Planning Application 19/02796/FULL OS Parcels 3309 & 4319 adjoining LNMR

Further to my previous letter of objection earlier this year please find below my additional response to the amendments.

1 North Elevation
1 : 100

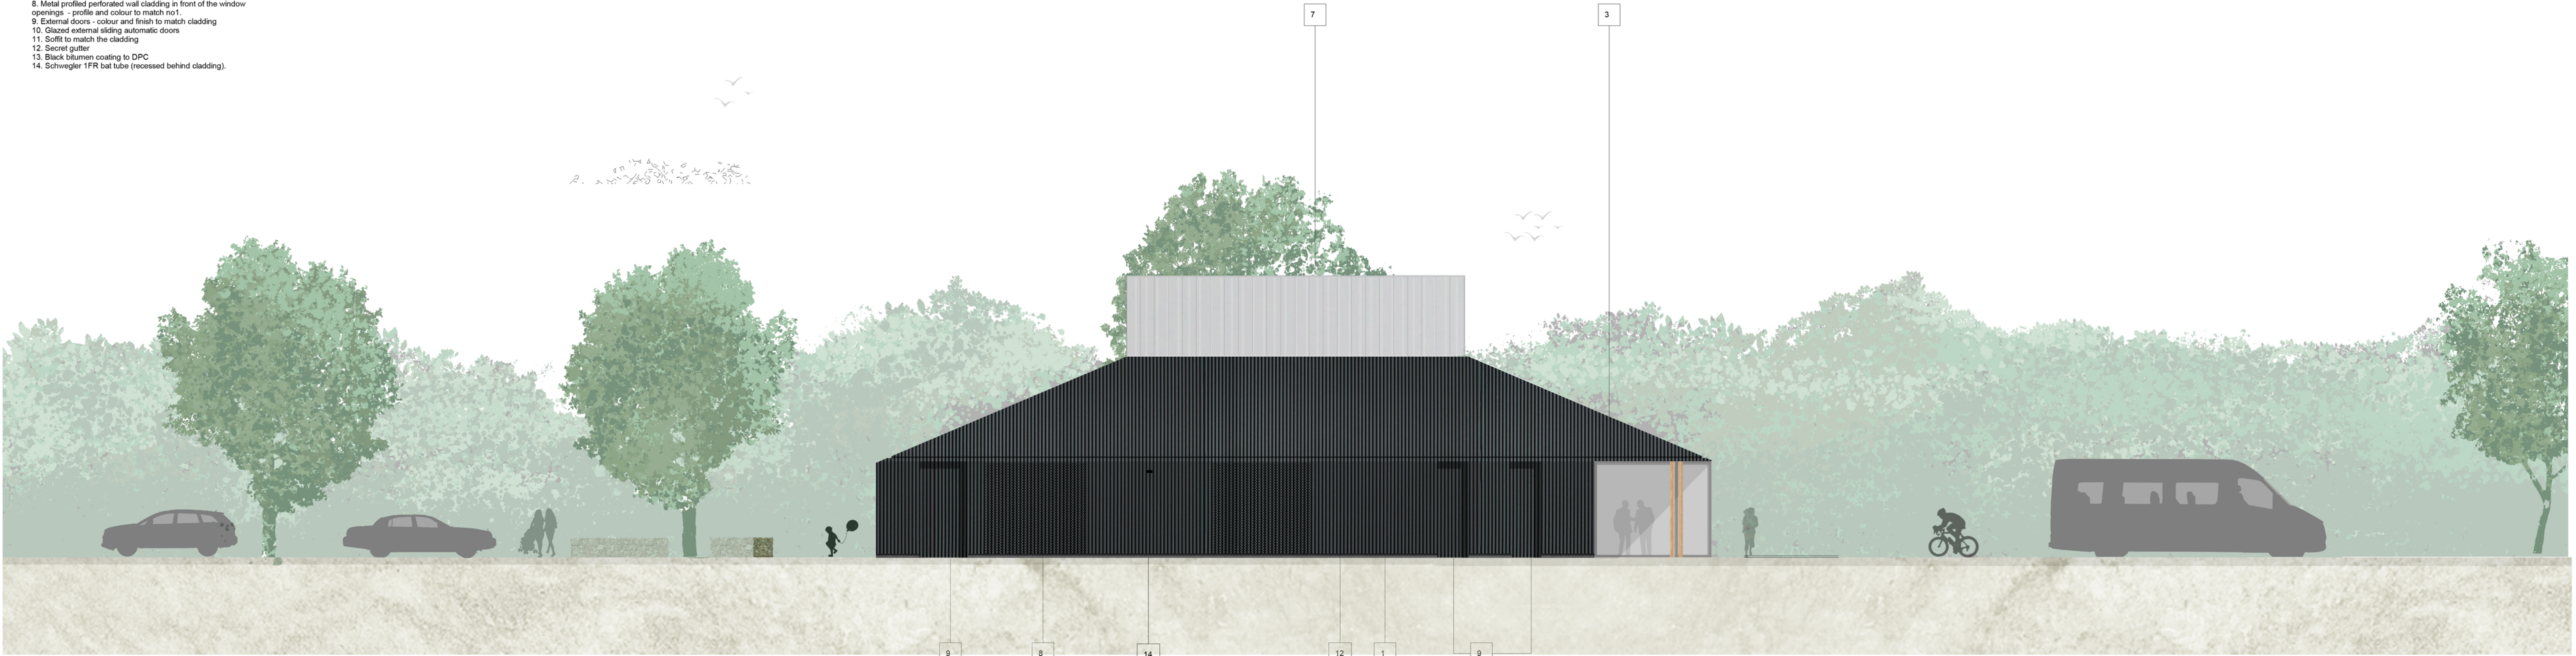
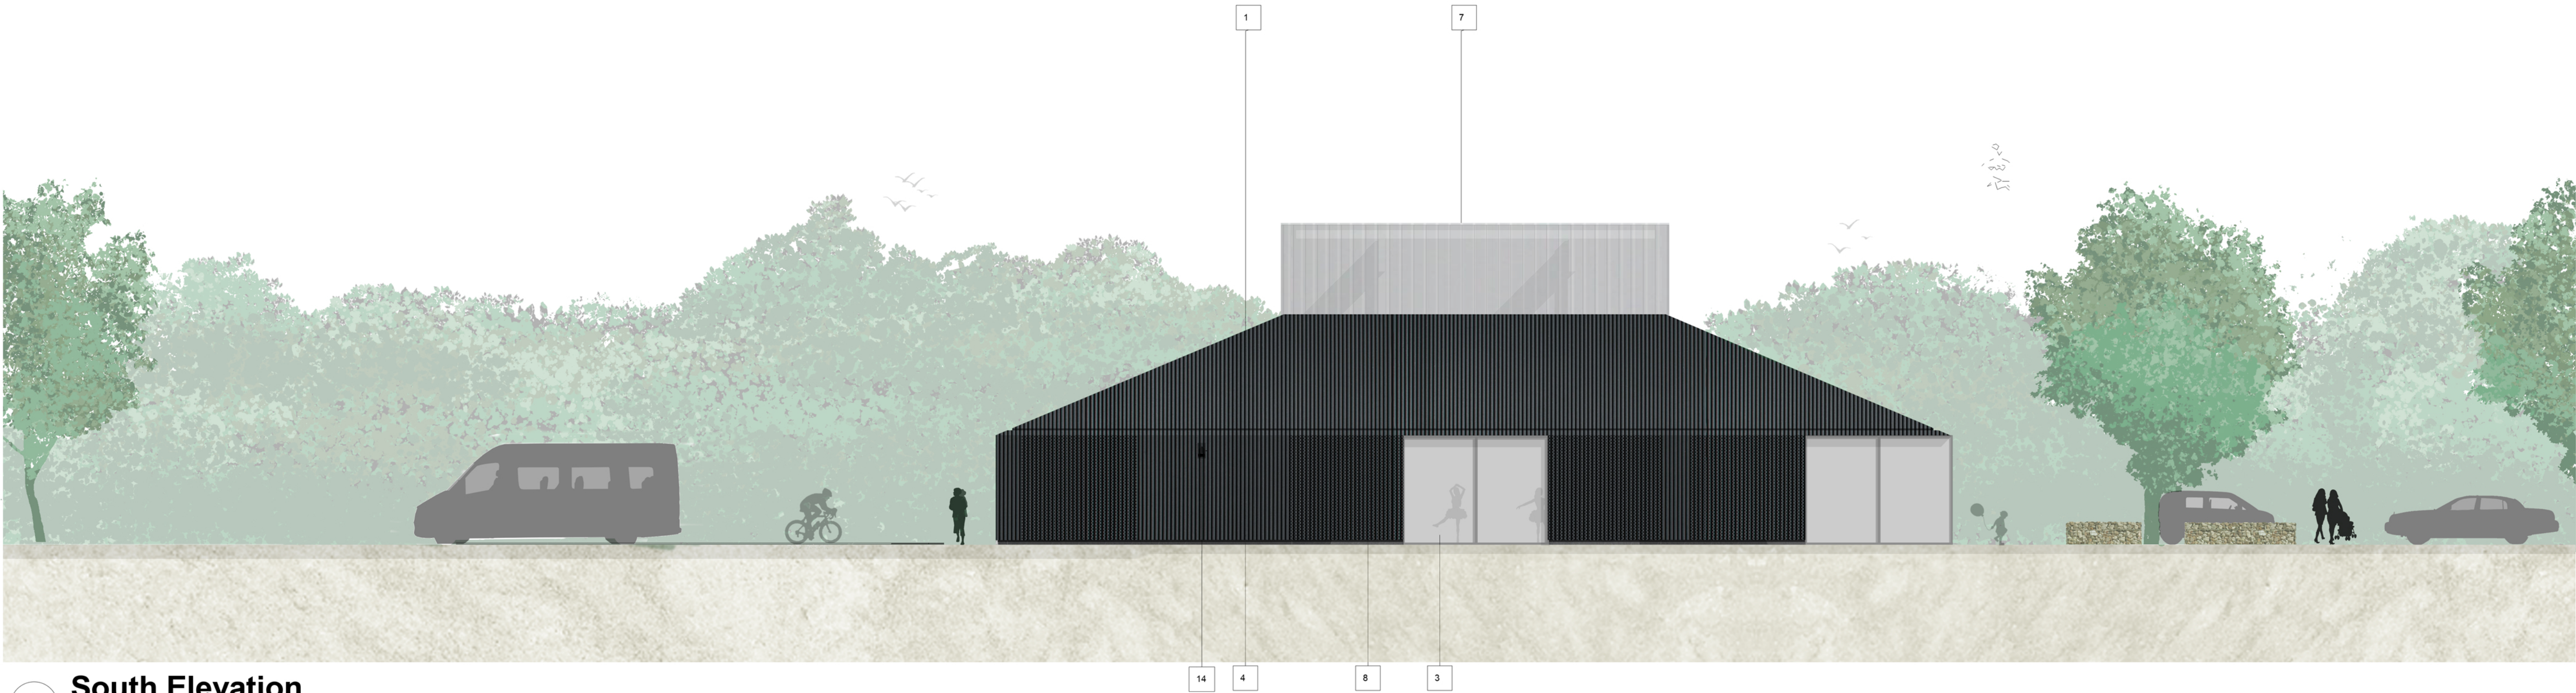
I consider the proposed external facings of the pavilion and its constructions materials ugly and inappropriate. Dark metal shutters are more suggestive of a penal facility than a vibrant community centre. The designers' claim that the dark colour will recede into the landscape like a rural barn are hard to reconcile with their assertion that it will also make a bold statement.
